MEMORANDUM

TO: City of Portland – Planning Board
FROM: Jim D. Wentworth, P.E.
DATE : February 21st, 2018
SUBJECT: Maine Medical Center – Constructability Review

Kleinfelder was tasked by the City of Portland’s Planning Department to assist in the constructability review for the vertical expansion of Maine Medical Center’s existing visitors parking garage.

1) Congress Street has to be closed for a period of 8 weeks. )

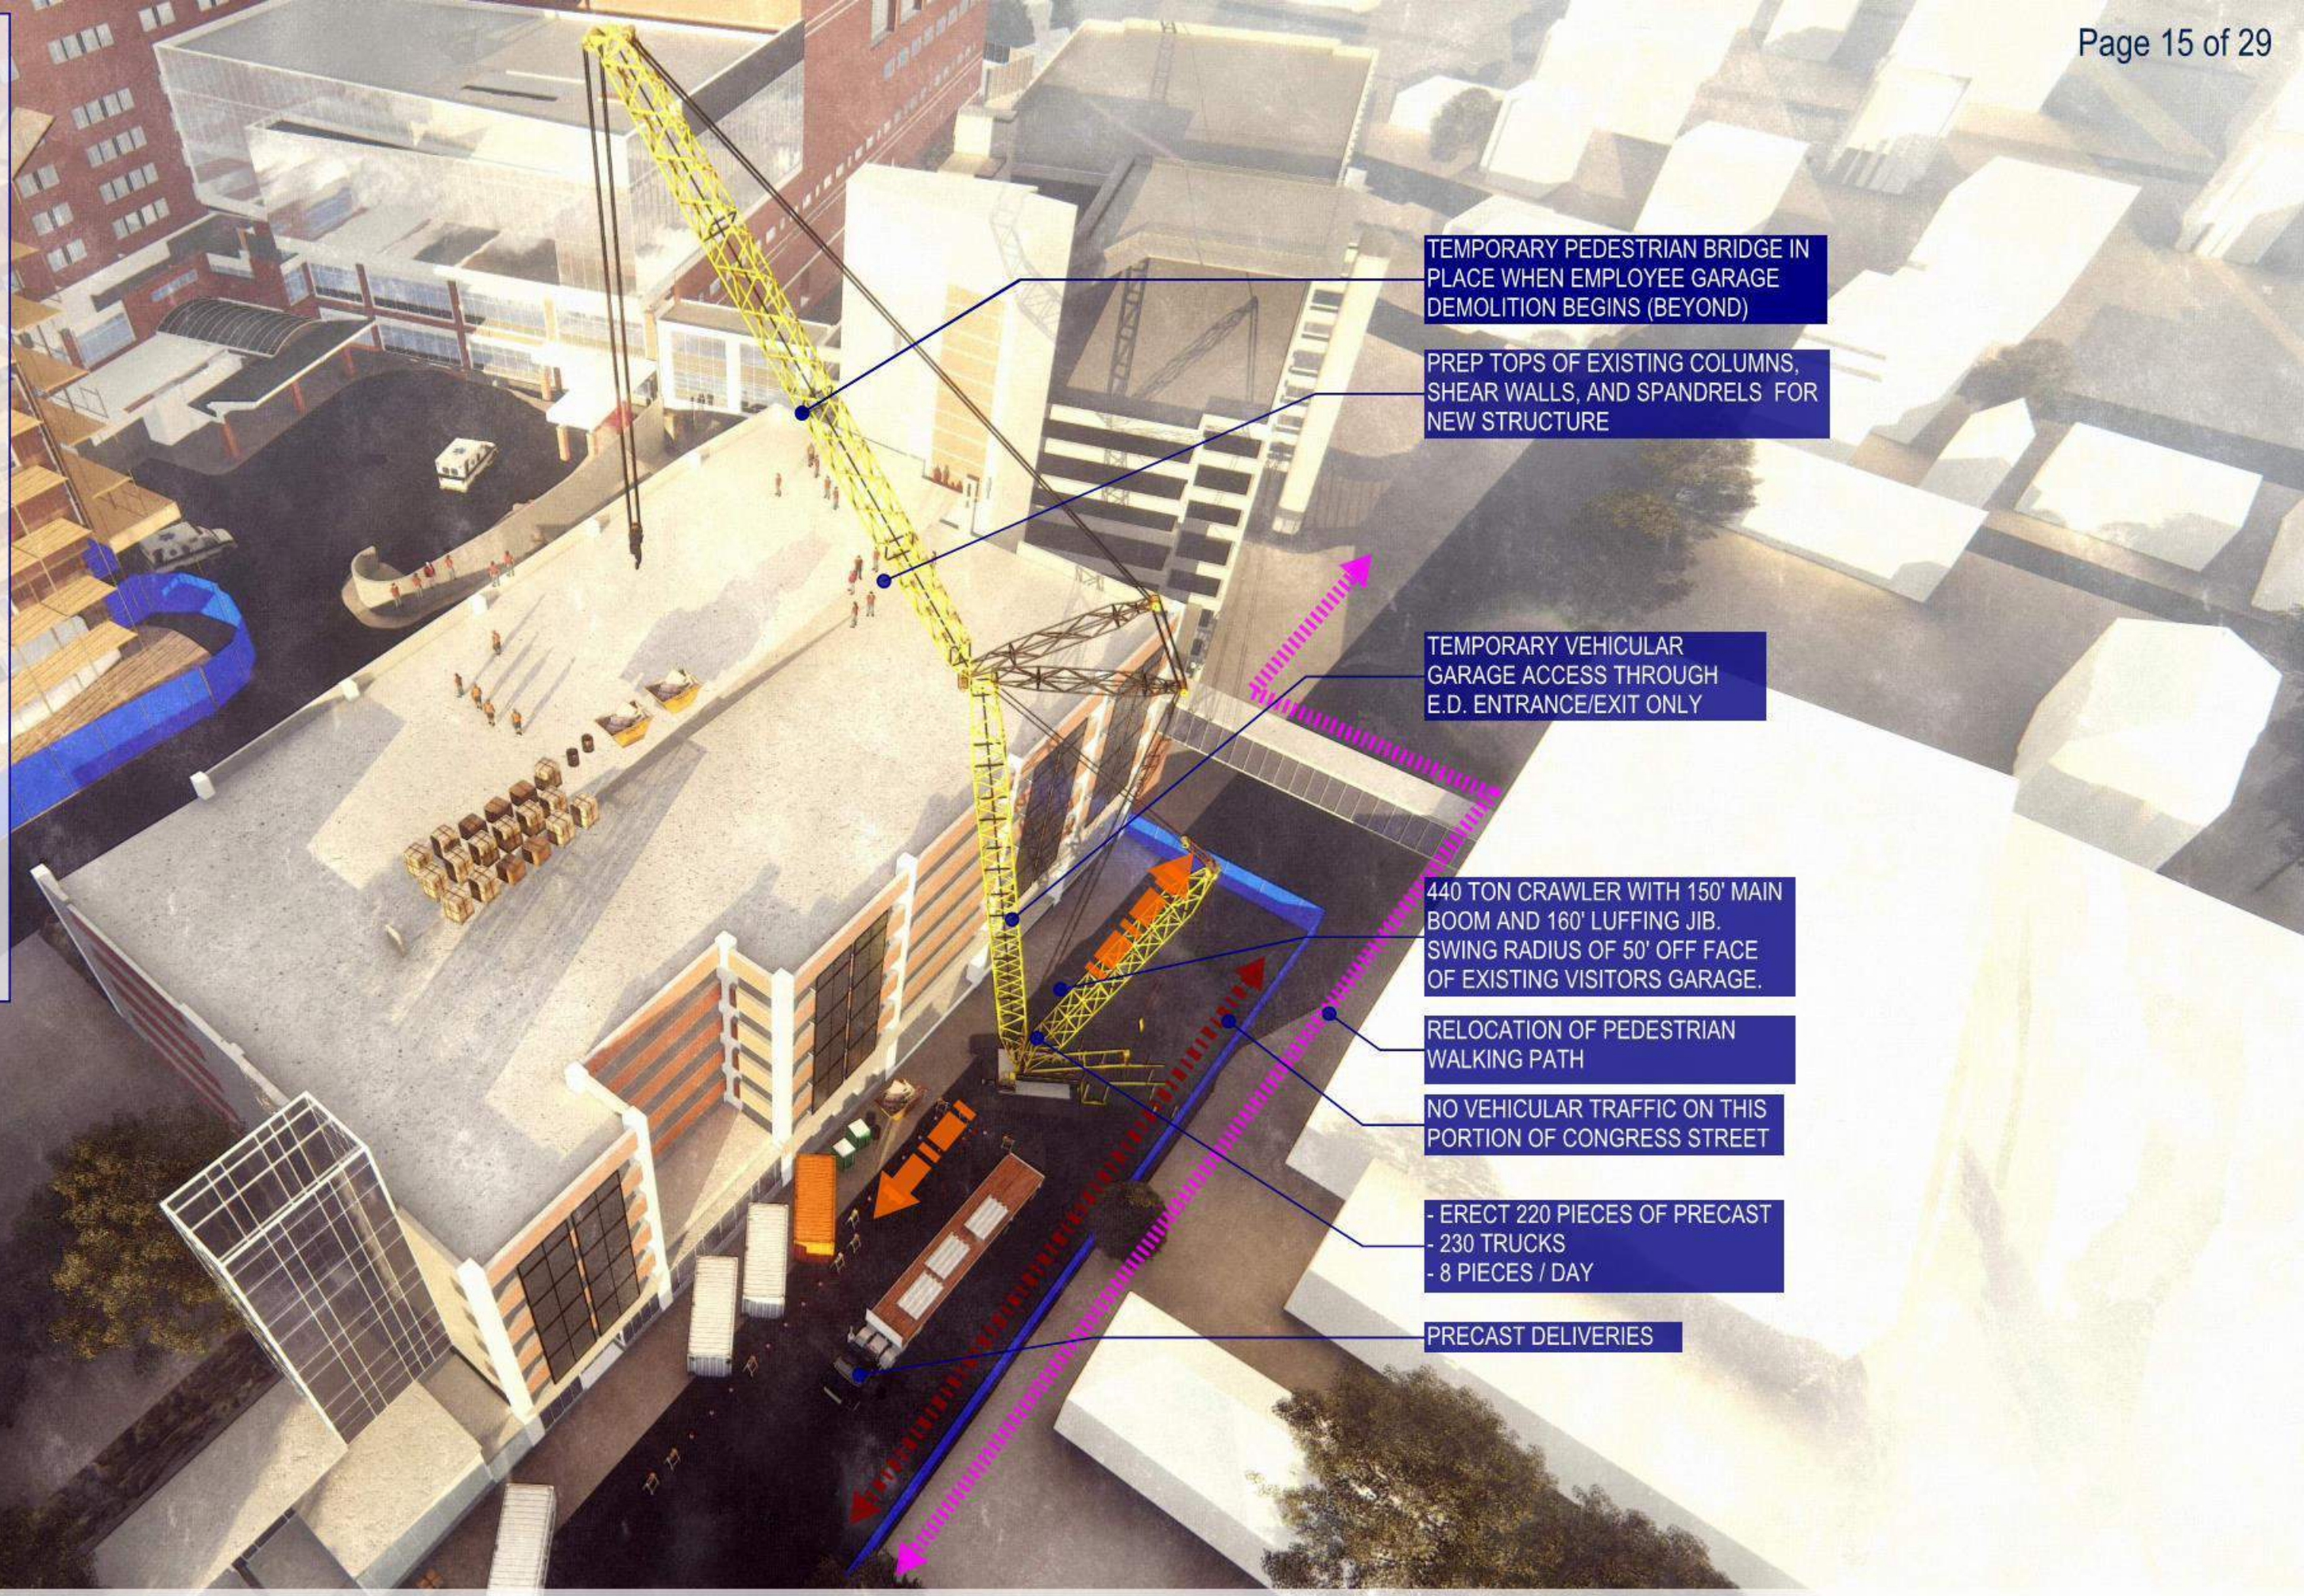
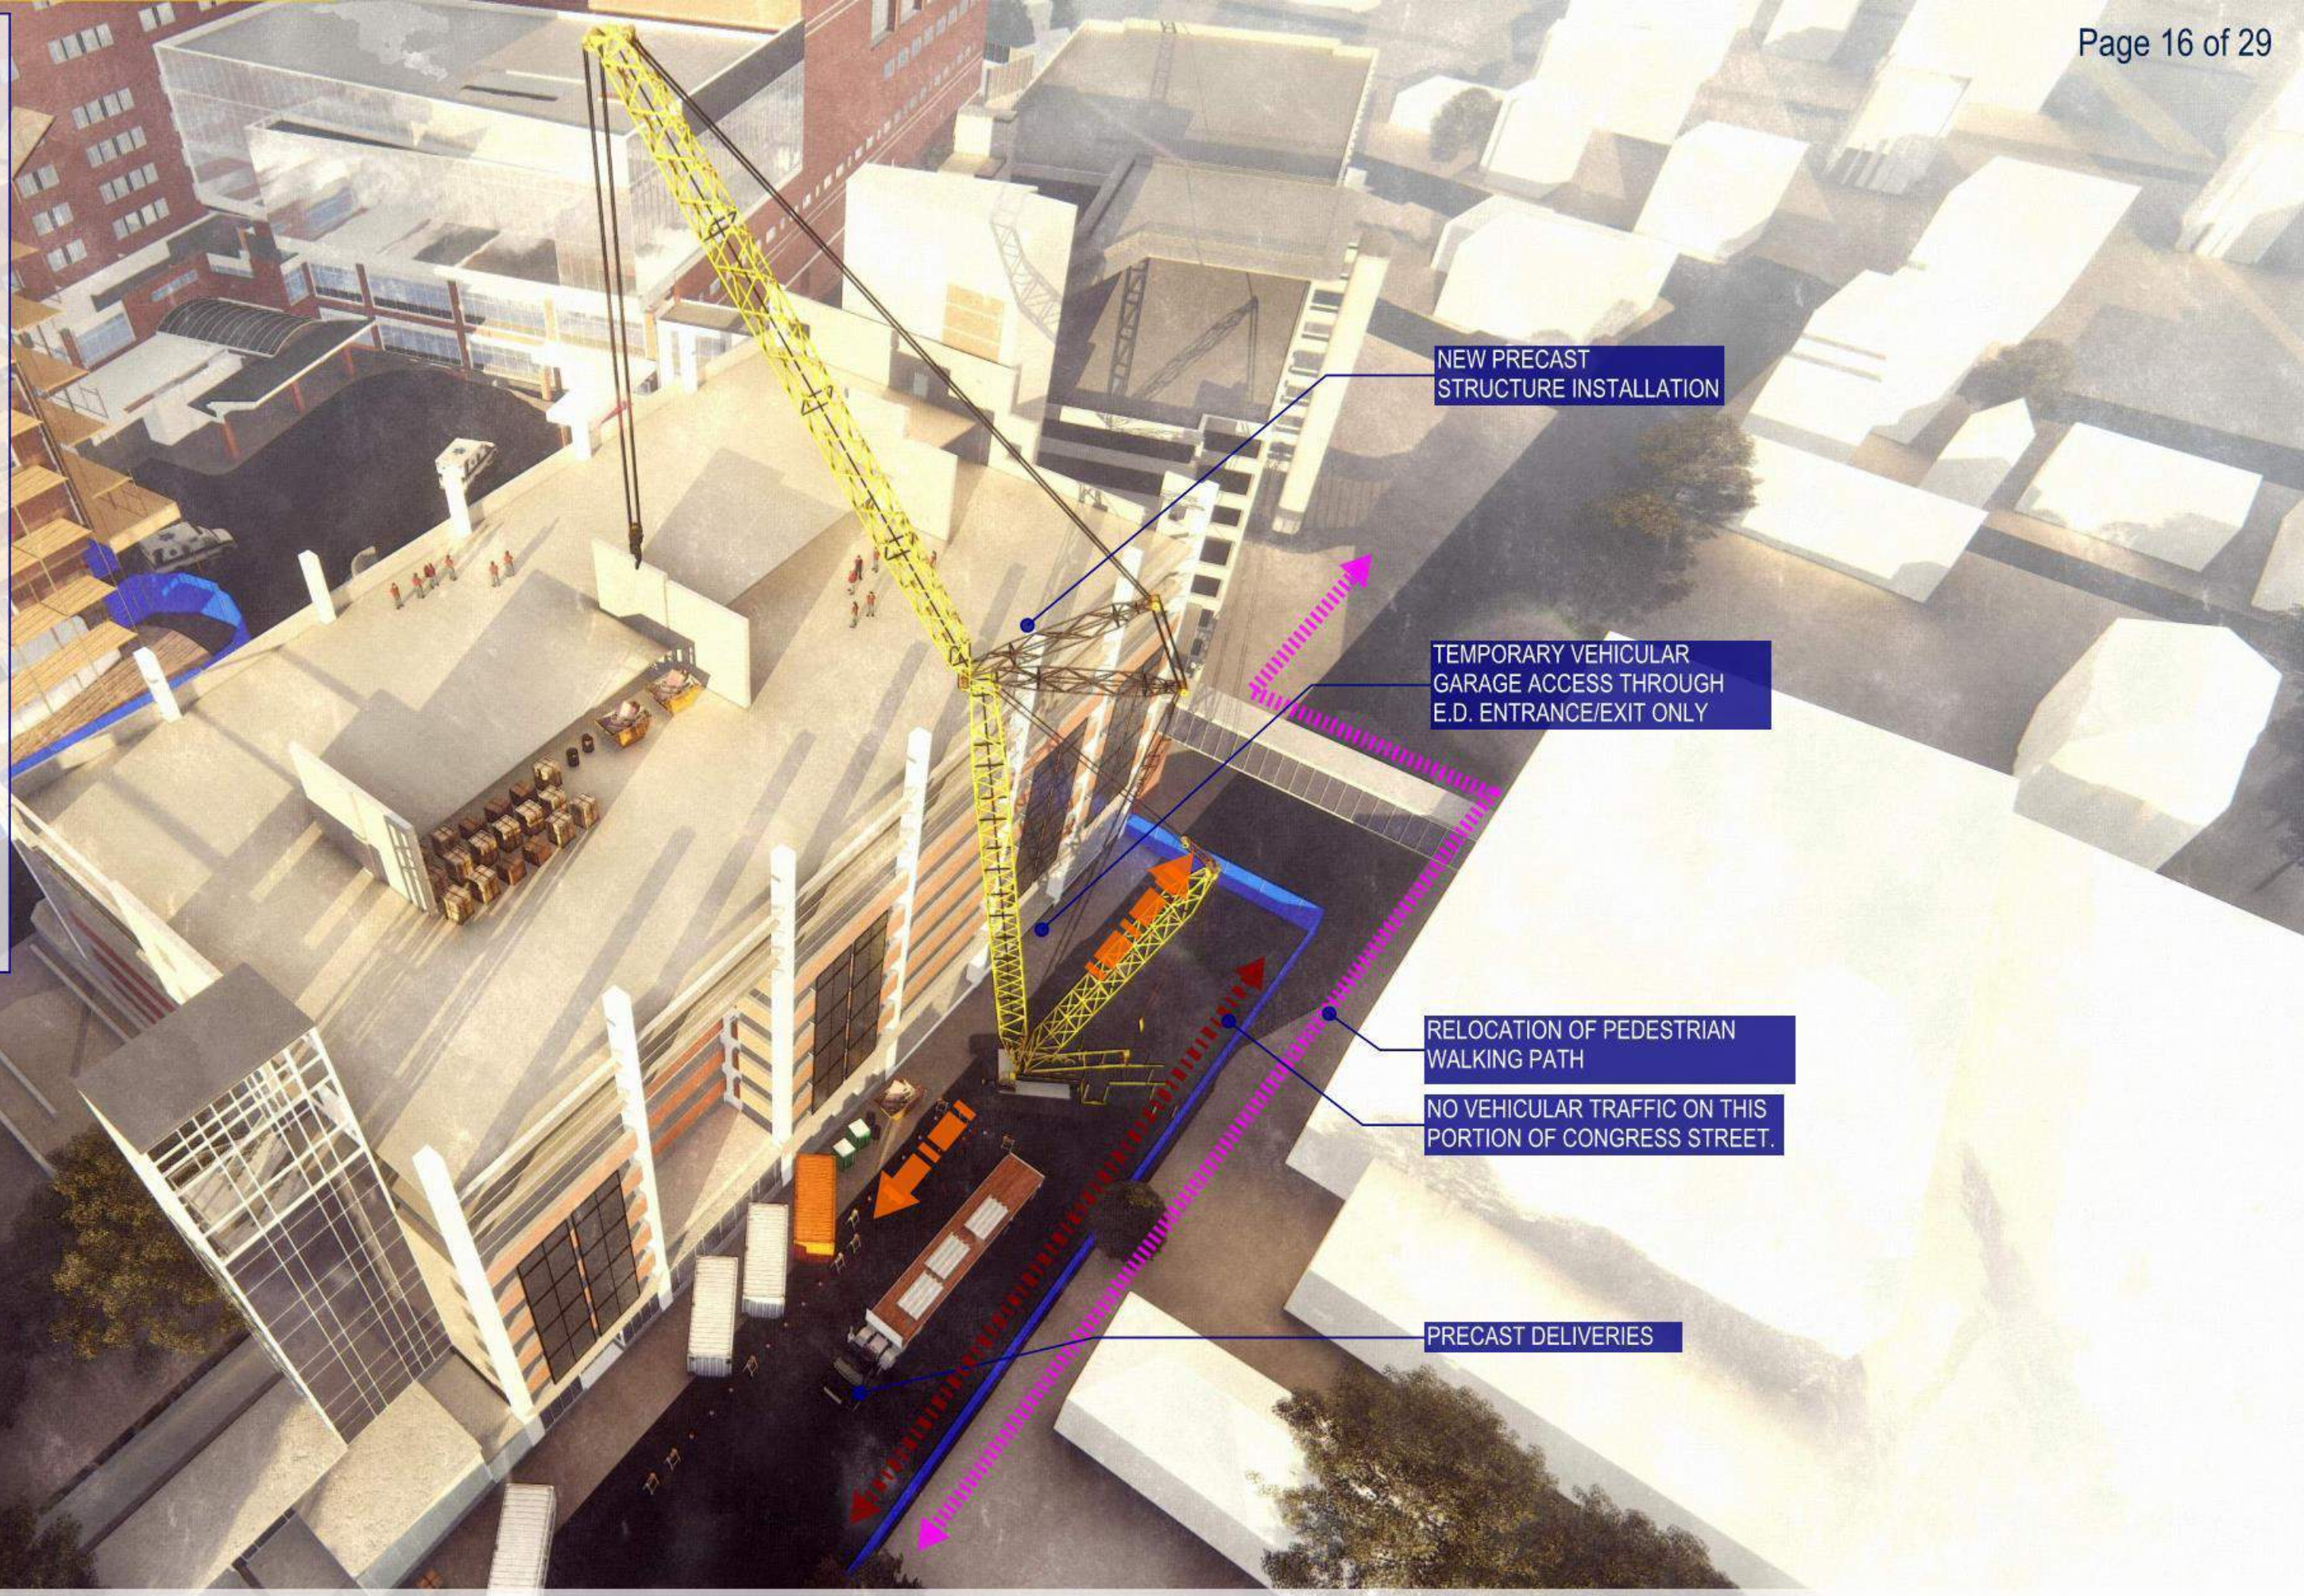
The overall construction schedule of an 8 week closure of Congress Street was reviewed and is listed below as *Schedule 1*. This schedule allows for 8 precast pieces set per day. It is realistic that 10 precast pieces may be set a day or even 12 pieces. It is also realistic that construction delays such as deliveries and/or adverse weather conditions may cause delays and allow only 6 pieces to be set per day.

It is recommended that the 8 week schedule be allowed, but set with allowable penalties for not opening on time.

It is not recommended to go to a 7 day work week as shown in Schedule 3. Consideration needs to be given in any schedule that as days get added to the work week there exists safety concerns with rested employees, decreased efficiency, a work area increase for complacency, as well as increase in cost premiums.

Closing Congress Street for an 8 week duration is the recommendation that Kleinfelder fully supports and would have proposed if developing this type of project independently for a client. It is recommended that the City work with Maine Medical Center to tighten up the schedule, as previously mentioned in this memo, with the use of incentive/disincentives, liquated damages associated with possible street damage, proper detour signing, and proper public outreach campaign.
